City of Albuquerque
Planning Department
Development Review Division
P.O. Box 1293
Albuquerque, New Mexico 87103

OFFICIAL NOTIFICATION OF DECISION

FILE: **Project # 1004927**
06EPC-00765 Sector Development Plan Zone
Map Amendment
06EPC-00777 Site Development Plan for
Building Permit

LEGAL DESCRIPTION: for all or a portion of Block 1, Lots 6-10 and 16-21, **University Heights Addition**, a zone map amendment from SU-2/UC & SU-2/R3C to SU-2/SU-1 for a Mixed Use Development, located on HARVARD DR. SE, between CENTRAL AVE. SE and SILVER AVE. SE, containing approximately 2 acres. (K-16) Stephanie Shumsky, Staff Planner

1 Site Plan for Building Permit
Scale: 1" = 20'-0"

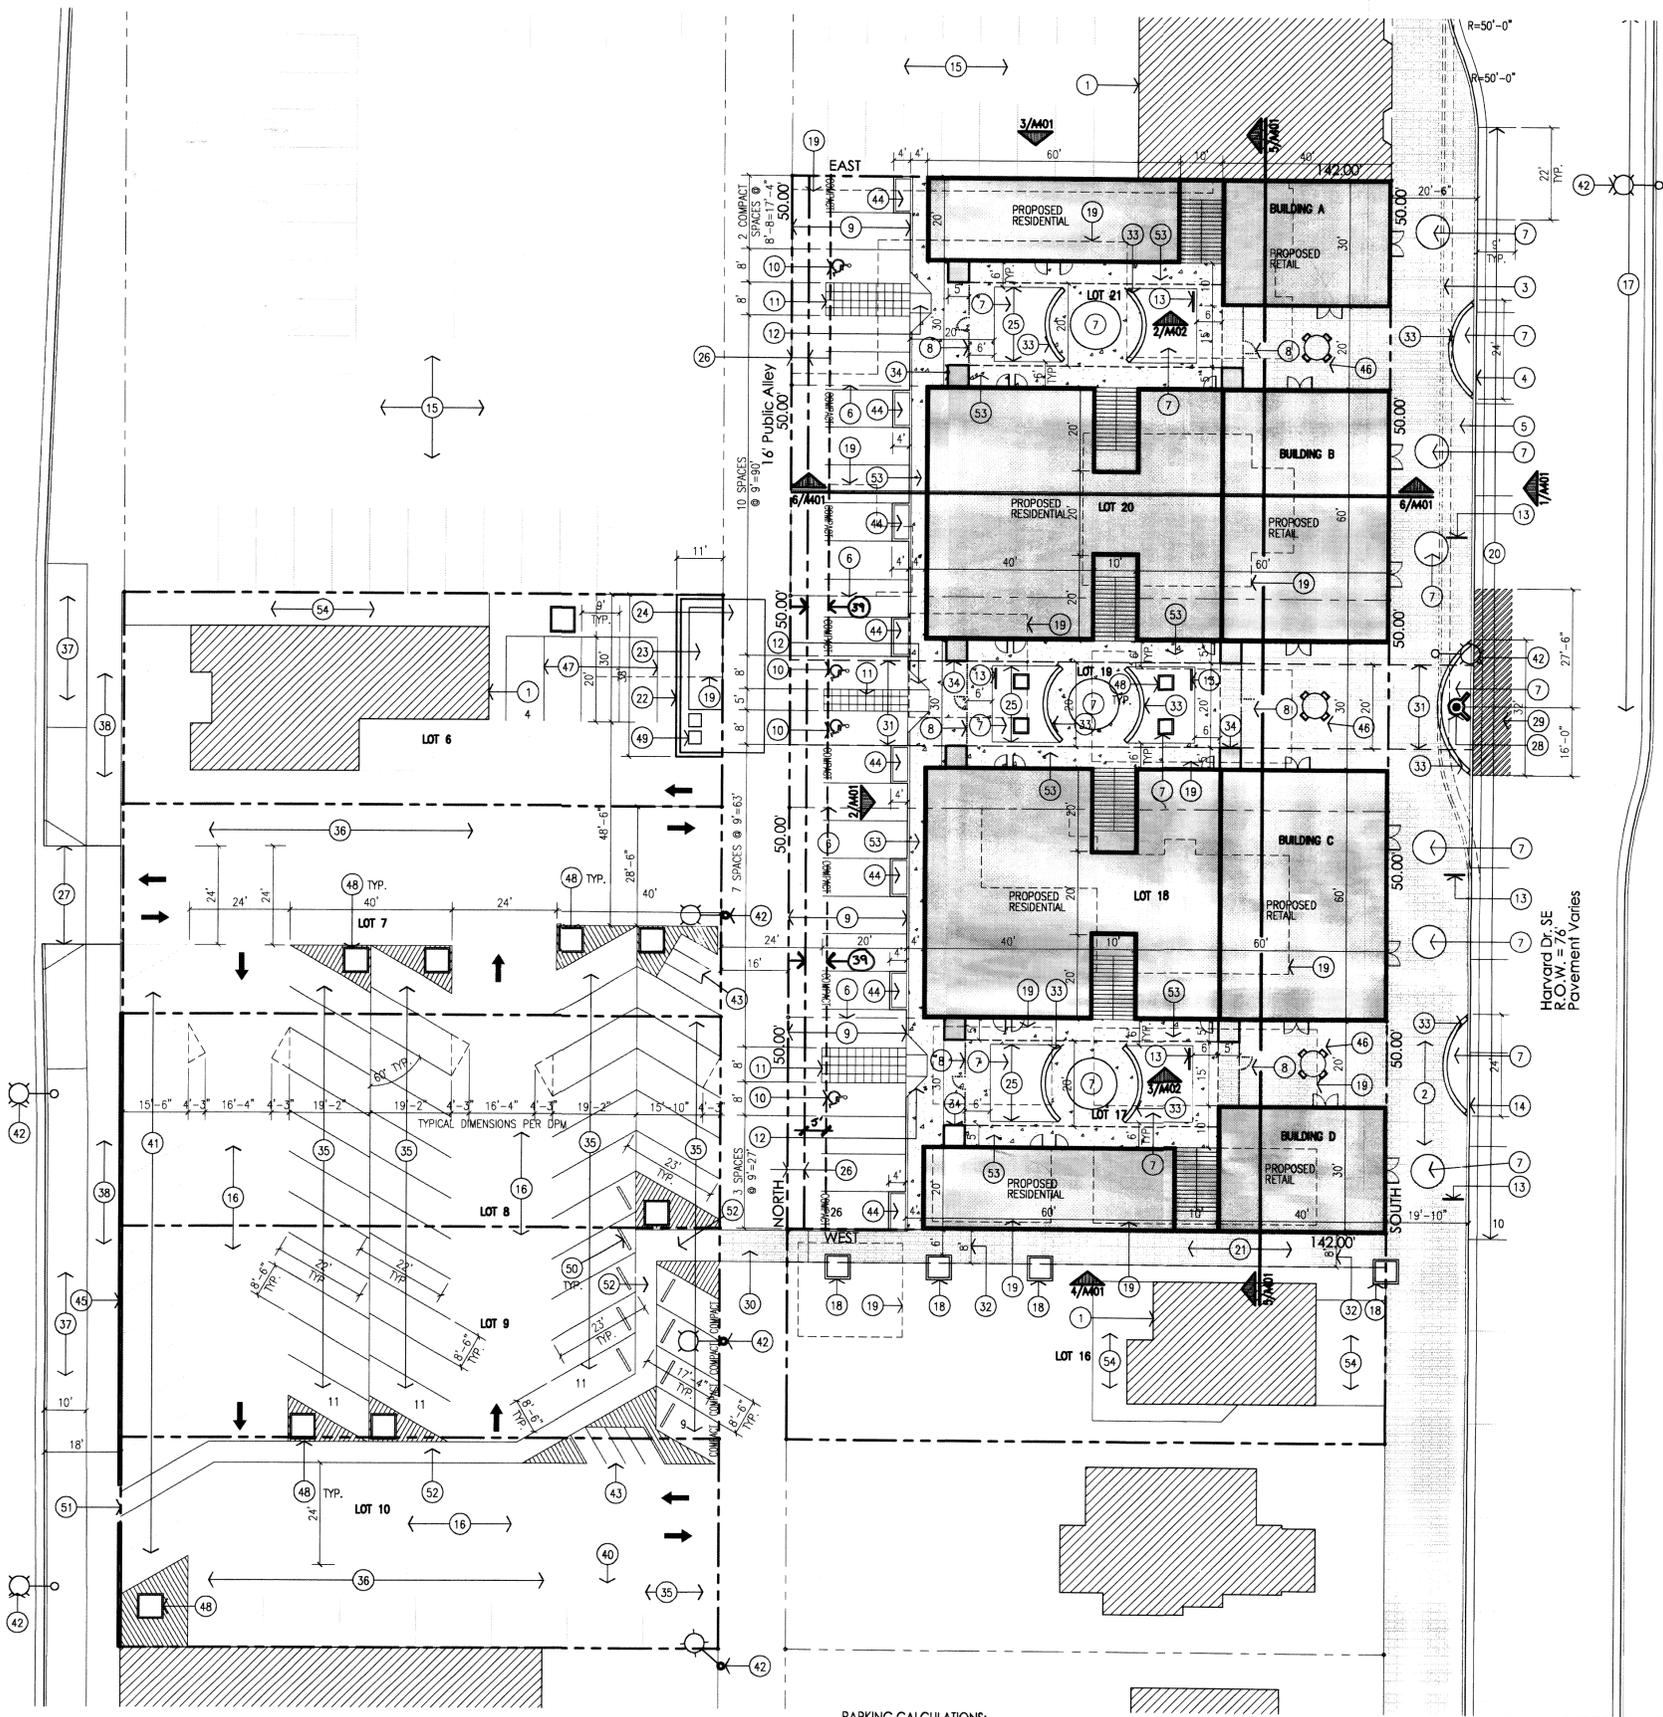
- b. Provide a detail of the 3-foot screen wall adjacent to the parking area along Yale Boulevard (#45 on Sheet A001).
 - c. A minimum 5-foot wide landscape buffer is required to separate the parking lot from the public sidewalk and 1 tree every 20' is required to be planted (*Staff note: 25' is acceptable for healthy growth and so as to be consistent with other City requirements*). Barriers shall be placed in the parking lot to prevent destruction of the landscape area (SDP requirement).

- d. The pedestrian walkway at the south end of the project (on lot 6) shall extend through the parking lot and shall connect to the public sidewalk adjacent to Yale Boulevard.

- e. Parking spaces must be 8.5' x 20' minimum except those with a designated concrete planter may be 8.5' x 16'.
7. Landscape Plan deficiencies to be addressed by the applicant prior to DRB submittal:
